03 March 2017

SSDA 7719 - SIGMA WAREHOUSE AND DISTRIBUTION CENTRE

This letter provides a formal response to the matters raised in the submissions and should be read in conjunction with the attached supporting information.

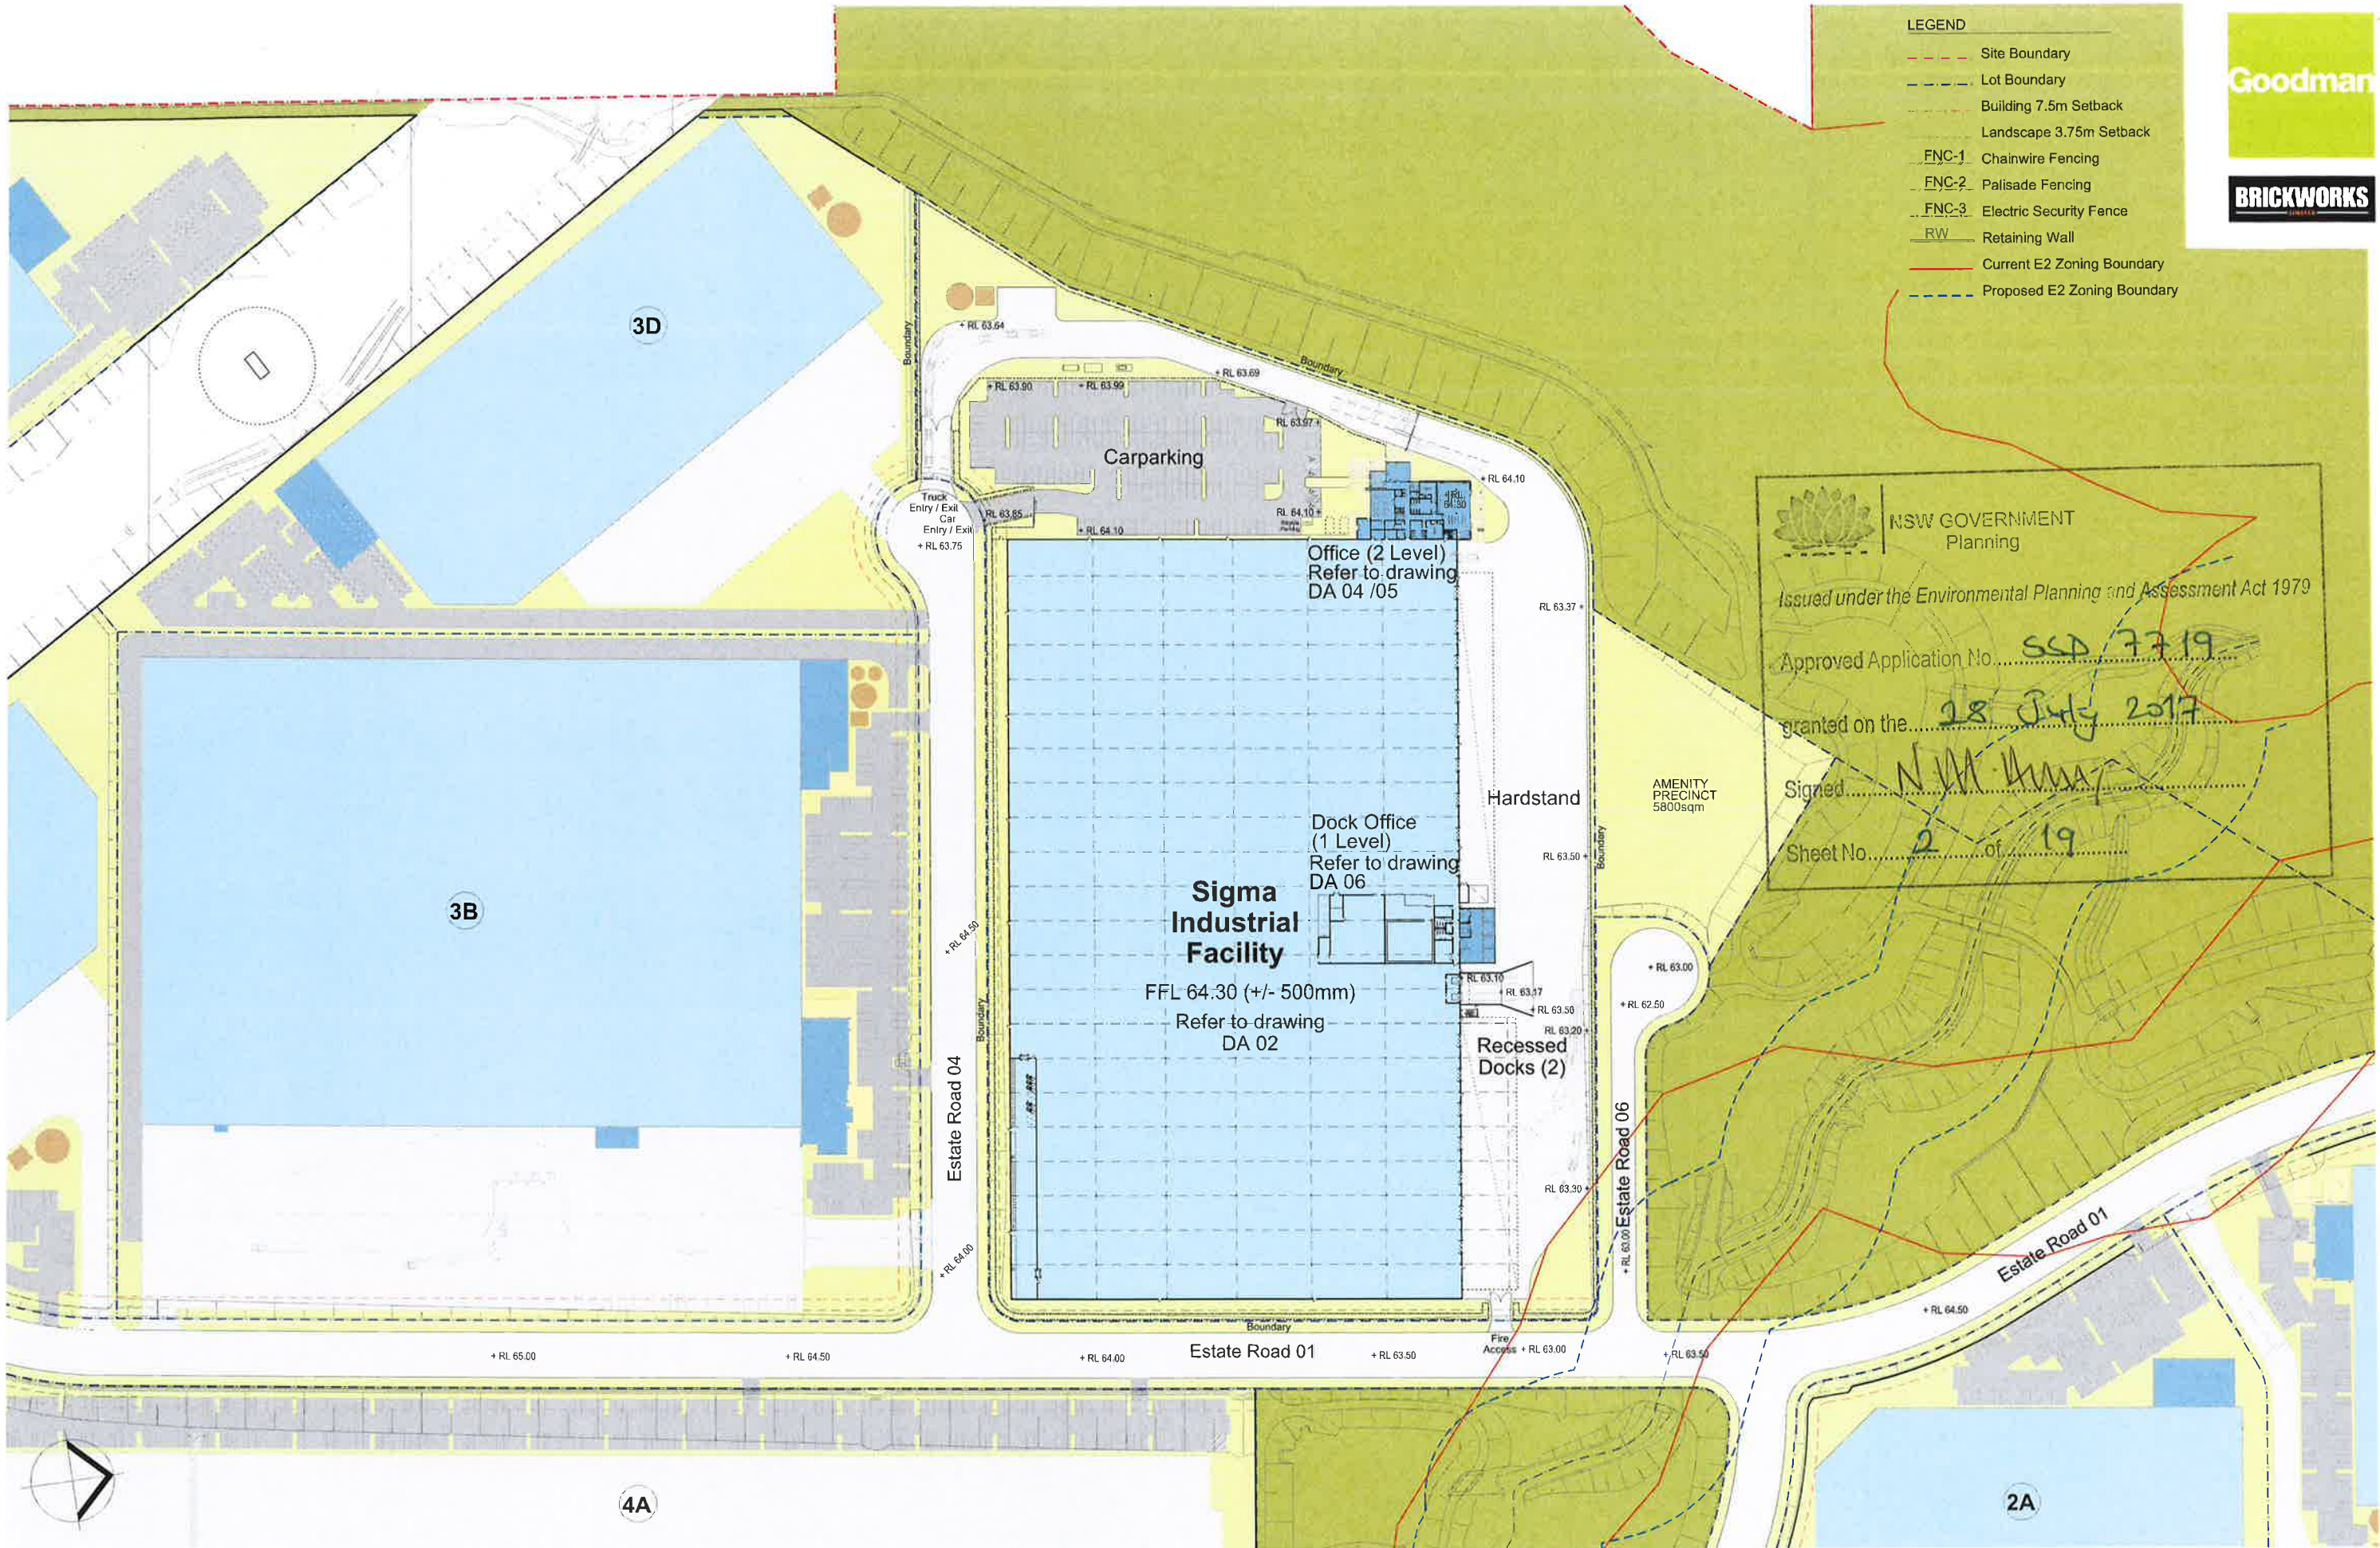
Matters Raised	Applicant consideration of matter/response
Construction jobs for Toyota [SIGMA ??]	The QS report has identified that 50 construction jobs will be created by the development.
Bicycle parking in the EIS but nothing shown in the plans	The Architectural Plans have been updated to show bicycle parking (refer to Attachment 4)
Signage for Sigma – no details included	Signage to be limited to direction signage only in line with Sigma’s operational and security requirements.
Northern boundary of landscaping 2.5m – sufficient landscaping?	The northern boundary landscaping is appropriate given the relative constraints of the site and the requirements for the location and size of the hardstand (refer to Options Analysis and layout options at Attachment 1 .
Palisade fencing – qualify set out of the fencing re: landscaping – recommend we move back	The location of the proposed fencing is consistent with this approach and as such considered to be acceptable in the context of the Stage 1 approval and site specific DCP controls.

101 K

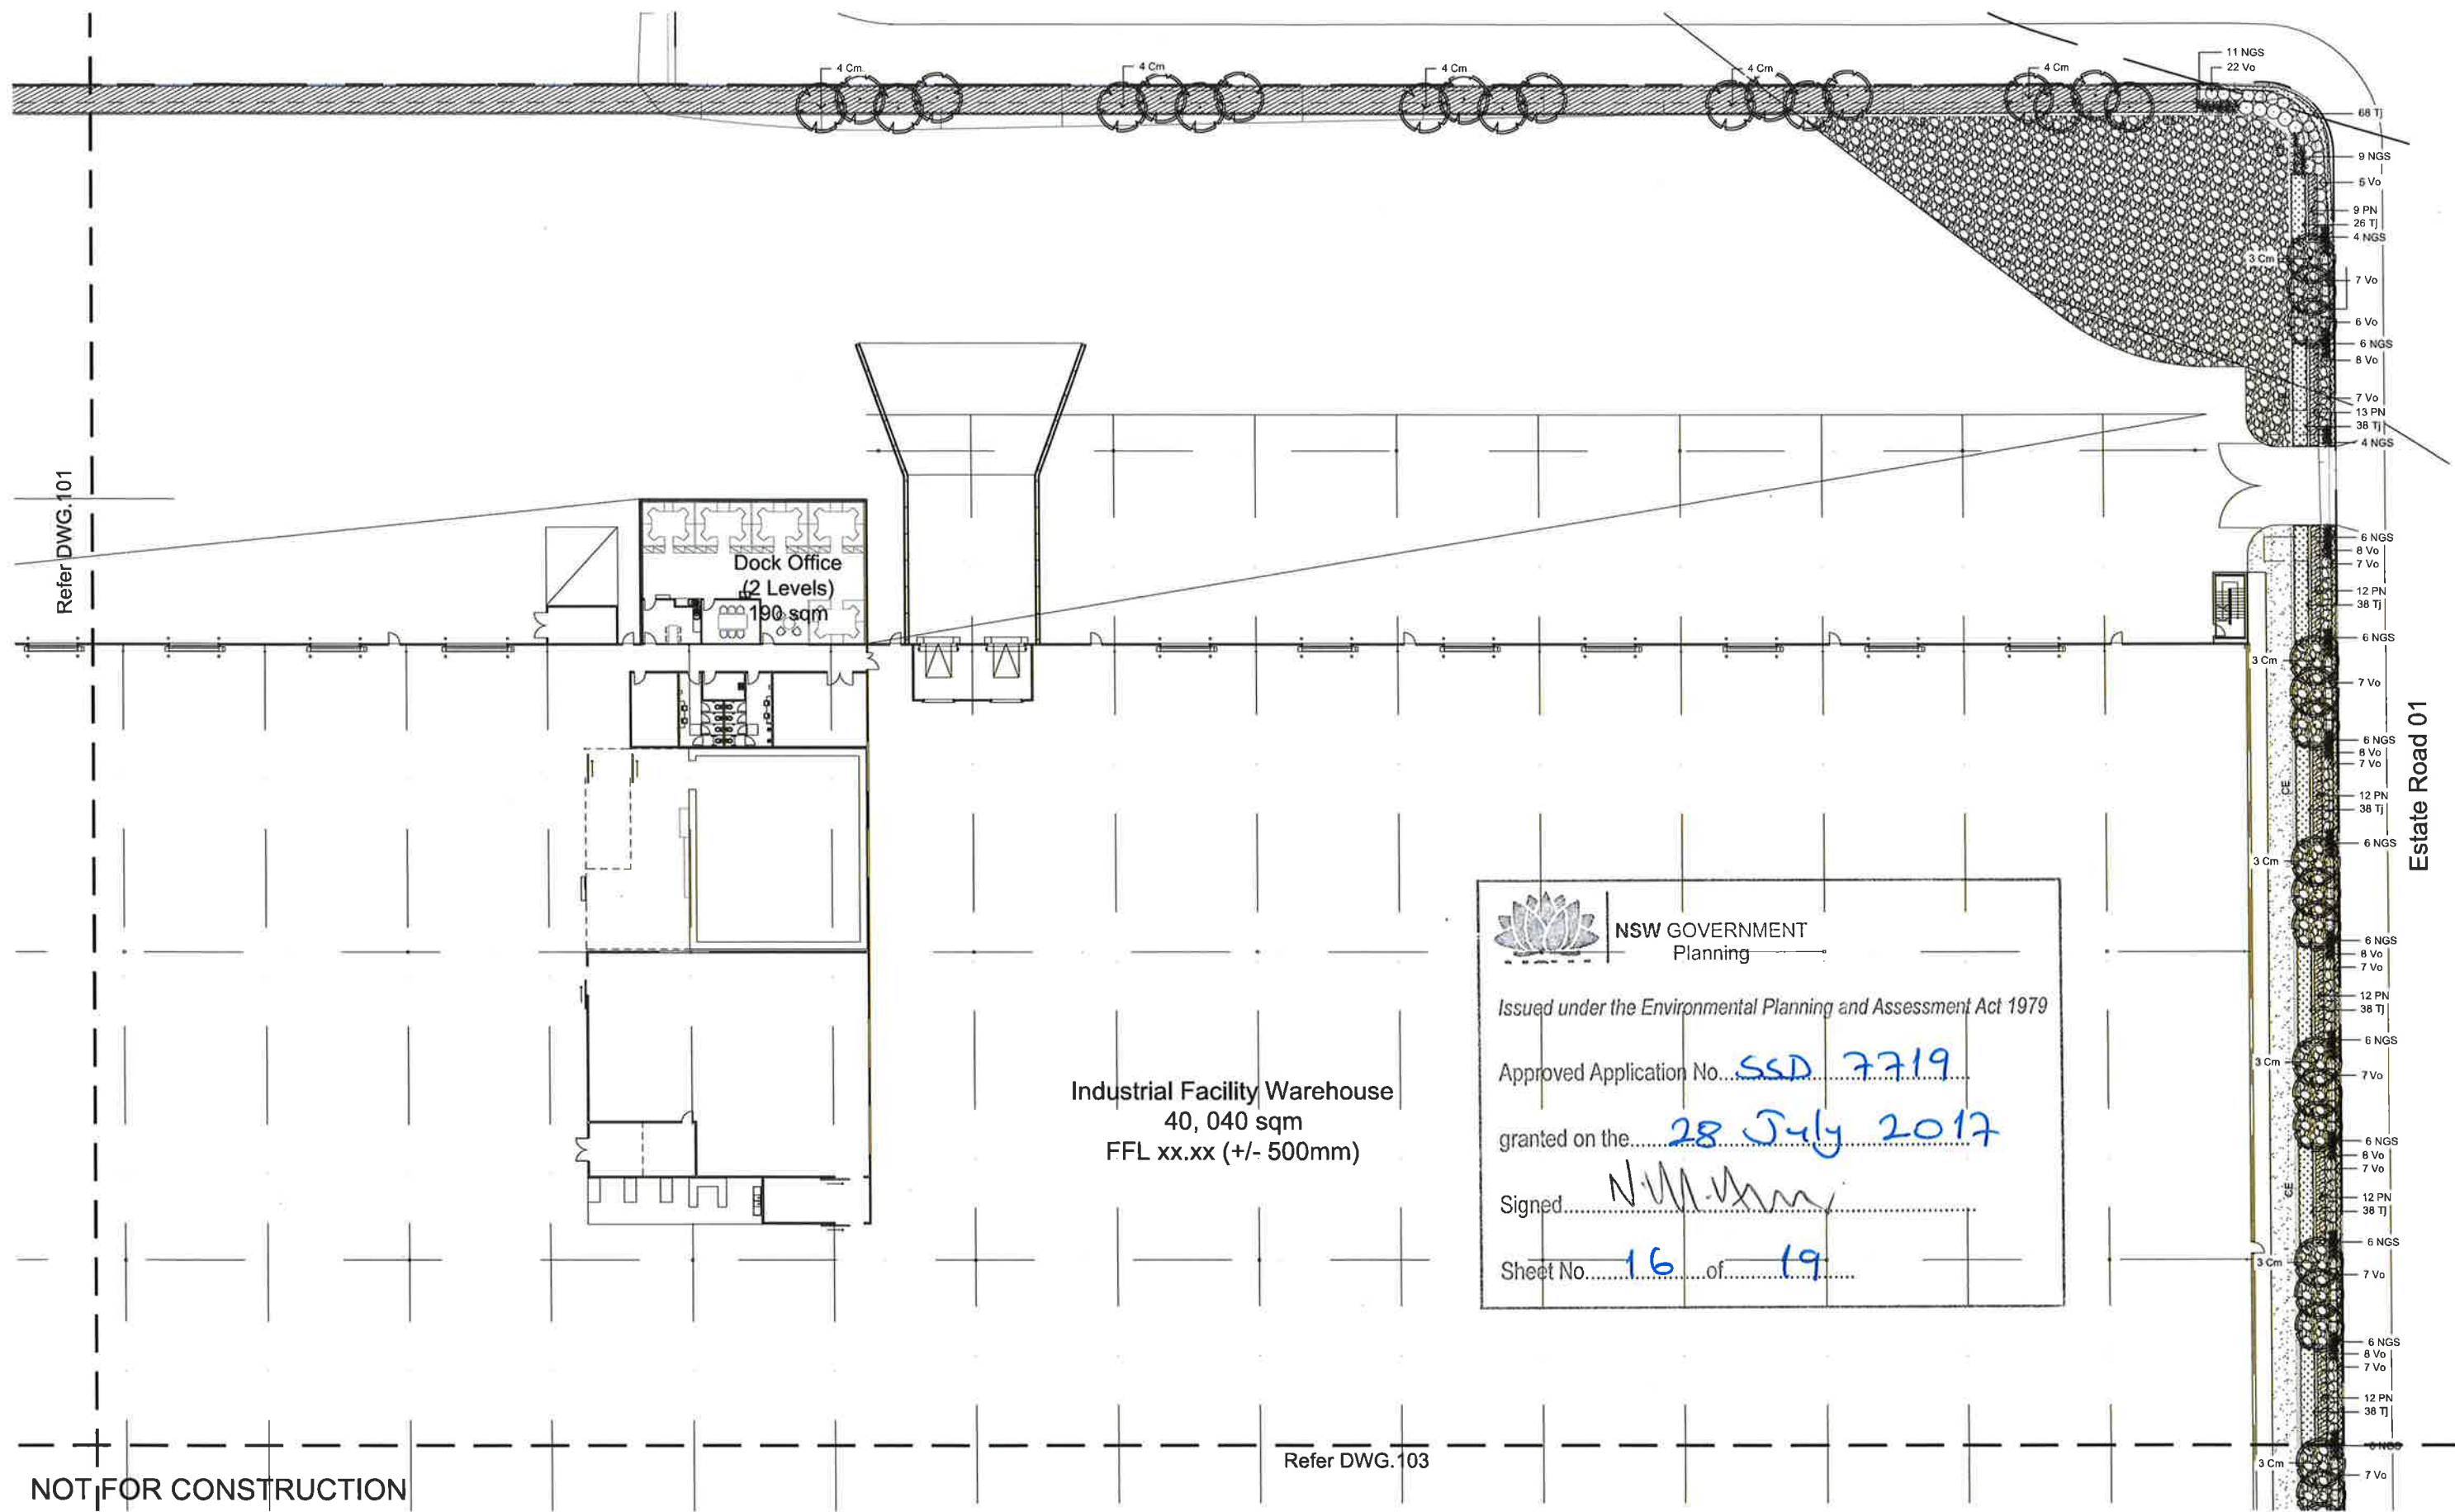
A landscaped buffer should be provided along the front of the most eastern car parking row providing a landscaped buffer to the building and pedestrian way. A landscaped buffer should be provided between the central car parking rows.	<ul style="list-style-type: none"> A landscape buffer along the front of the most eastern car parking row would hinder pedestrian access and is not considered appropriate. It should be noted that the proposed landscaping for the car park is consistent with landscape treatment approved across Oakdale Central and South and is considered to provide good amenity and shading for users.
It is noted that tree and shrub species locations are not identified on the submitted landscape plans.	The Landscape Plans have been updated to include plant labels, as requested. Trees and planting will be selected in accordance with the schedules on the Landscape Cover Sheet DWG No. 000. Landscaping for these areas will ensure that appropriate shade throwing trees are selected
